WEST SUSSEX COUNTY COUNCIL CONSULTATION

TO:	Arun District Council FAO:
FROM:	WSCC - Highways Authority
DATE:	28 September 2021
LOCATION:	Fort Road Garage Fort Road East Wick Littlehampton BN17 7QZ
SUBJECT:	LU/276/21/PL Demolition of existing storage structure, proposed 2 storey commercial building class B1 and B8. This application is in CIL Zone 4 (zero rated) as other development.
DATE OF SITE VISIT:	n/a
RECOMMENDATION:	No objection
S106 CONTRIBUTION TOTAL:	n/a

PROPOSED SITE BLOCK PLAN

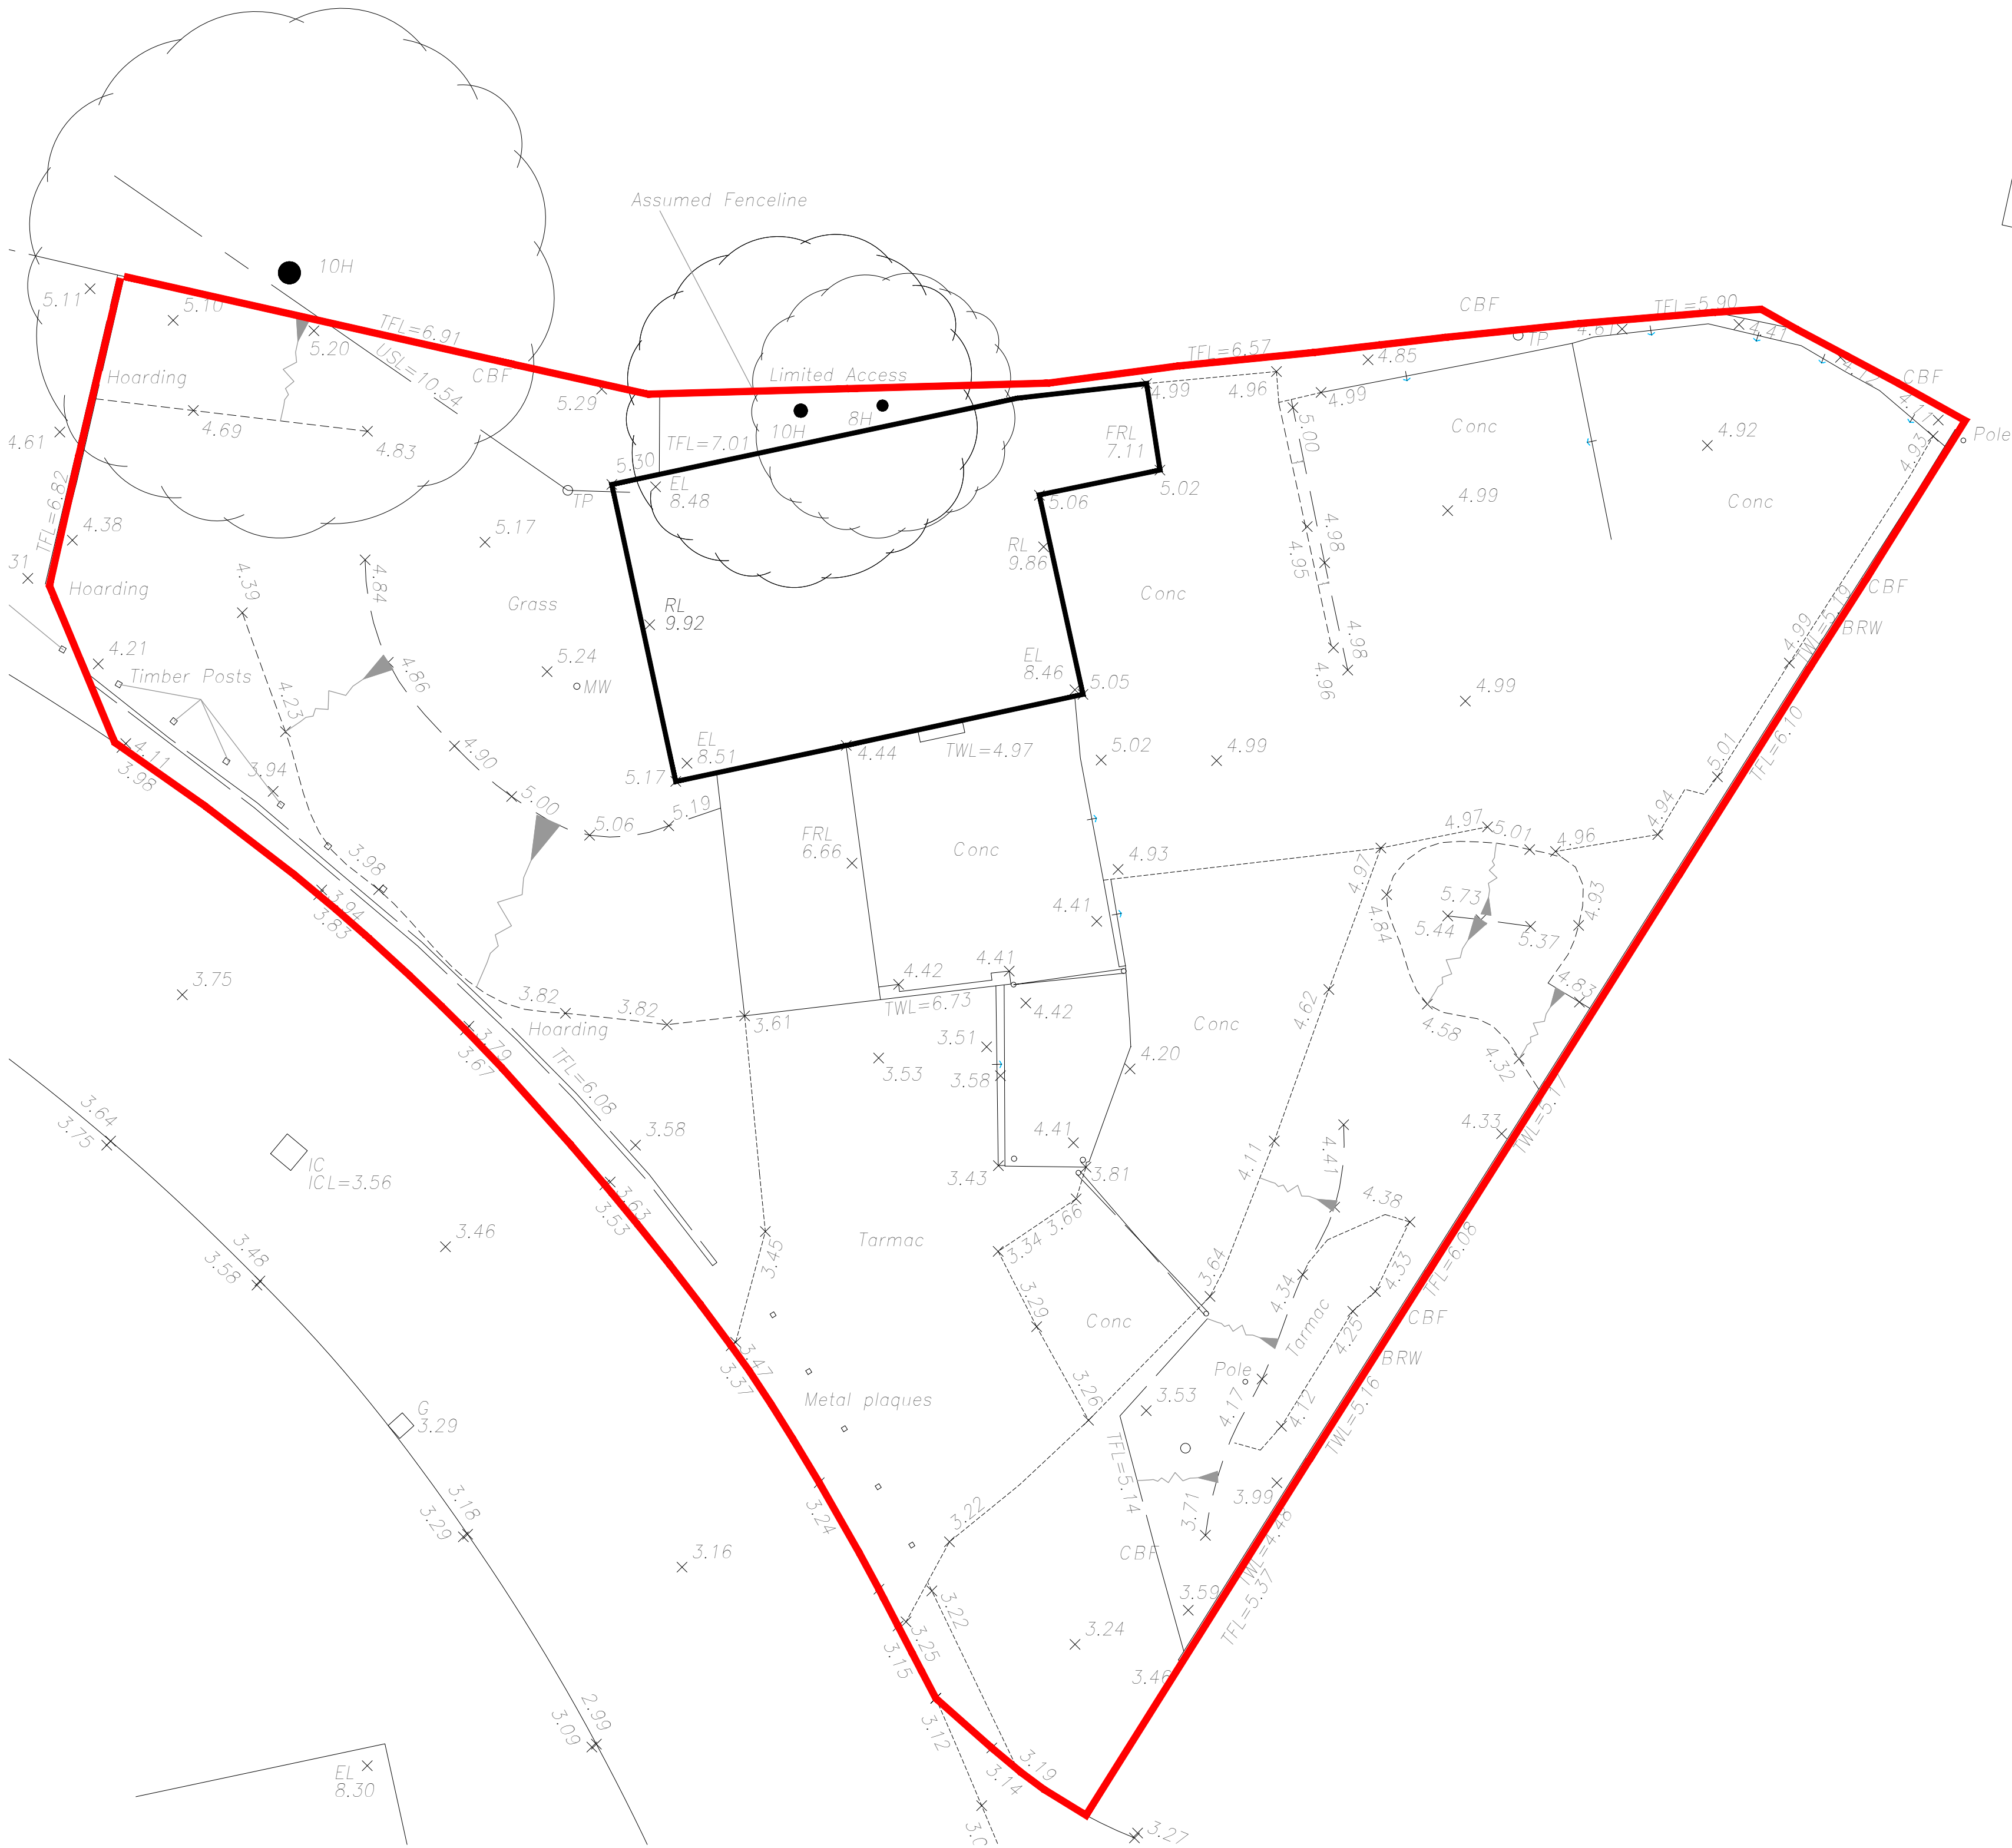
It is proposed that the delivery vehicles can turn within the parking space provided to the north east of the site, however no tracking diagrams are provided for delivery or emergency vehicles.

Manual for Streets states that waste collection vehicles should be able to get to within 25m of the refuse collection point. Bin stores for the development are provided further away, to the north east of the site. The Local Planning Authority (LPA) would request for clarification from the applicant about the refuse collection arrangements.
